Application No: EP/128/20/HH
Site Address: 48 Angmering Lane East Preston BN16 2TA
Description of works: Erection of a two storey rear extension. Existing brick house to be rendered in white with alterations to fenestration

Thank you for your internet representation made on 11th November 2020 which has been recorded as an objection with the comments as follows:

Drawing No. 0010 Drawing Name: Proposed Elevations

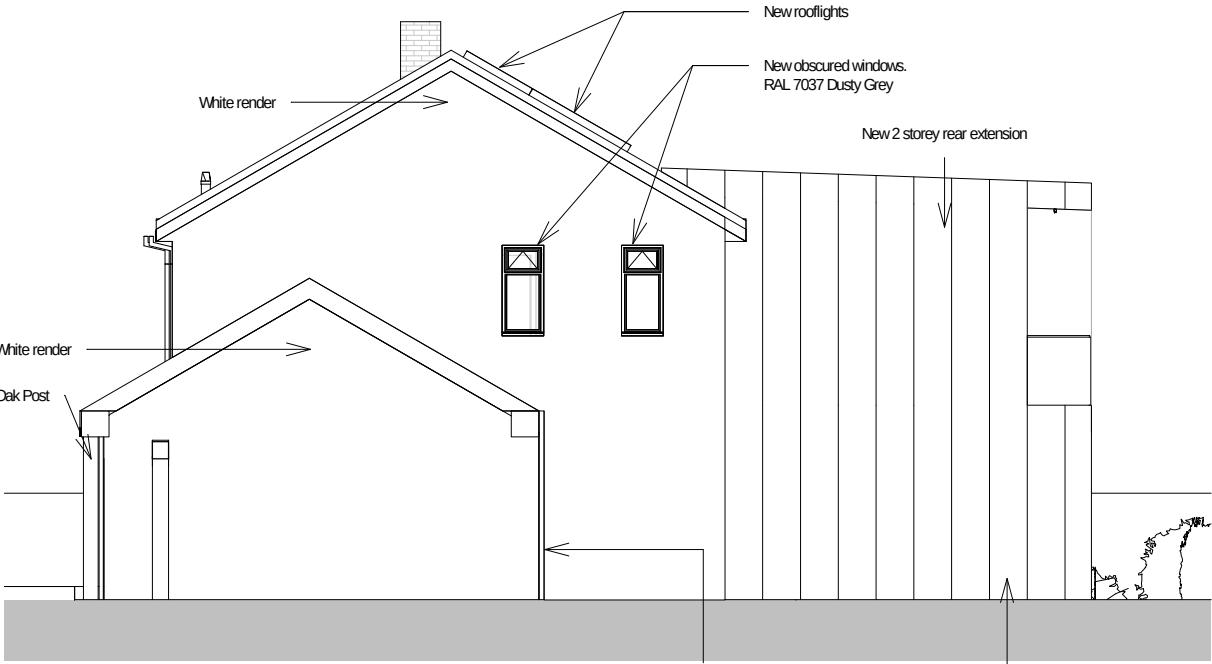
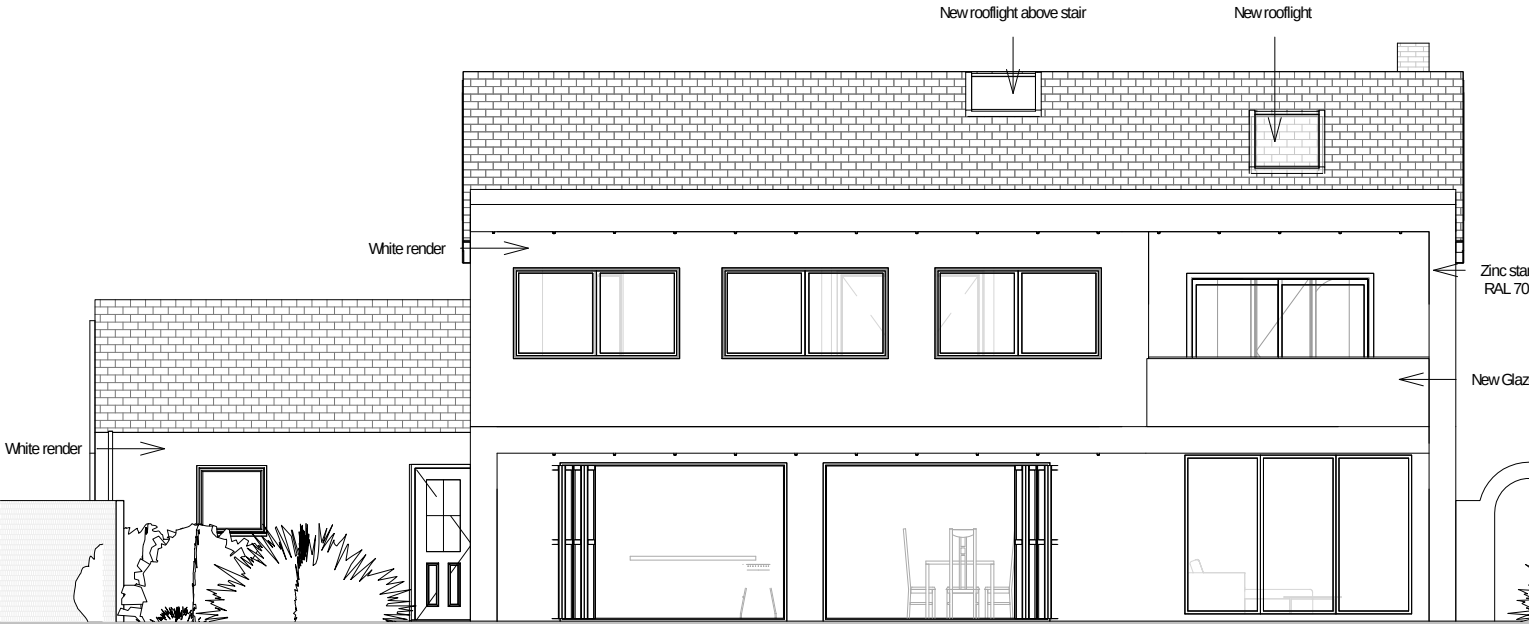
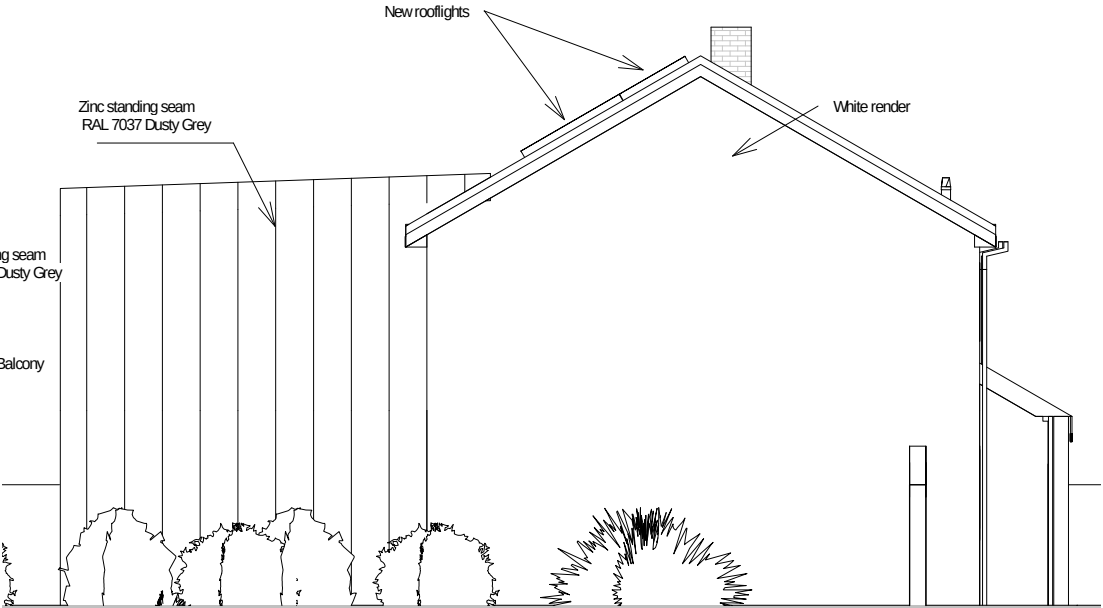
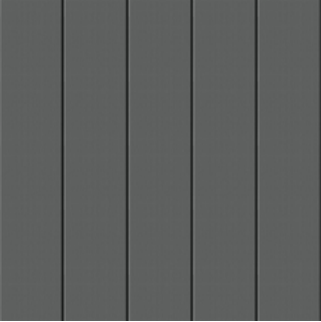
We live at no50 Angmering Lane. We are not opposed to the extension (new windows overlooking our property being obscured) however we do object to the use of zinc cladding which is out of keeping with the house and properties in Angmering Lane. It does not look part of the design of the house and the side elevation on our side looks like a metal box added to it.
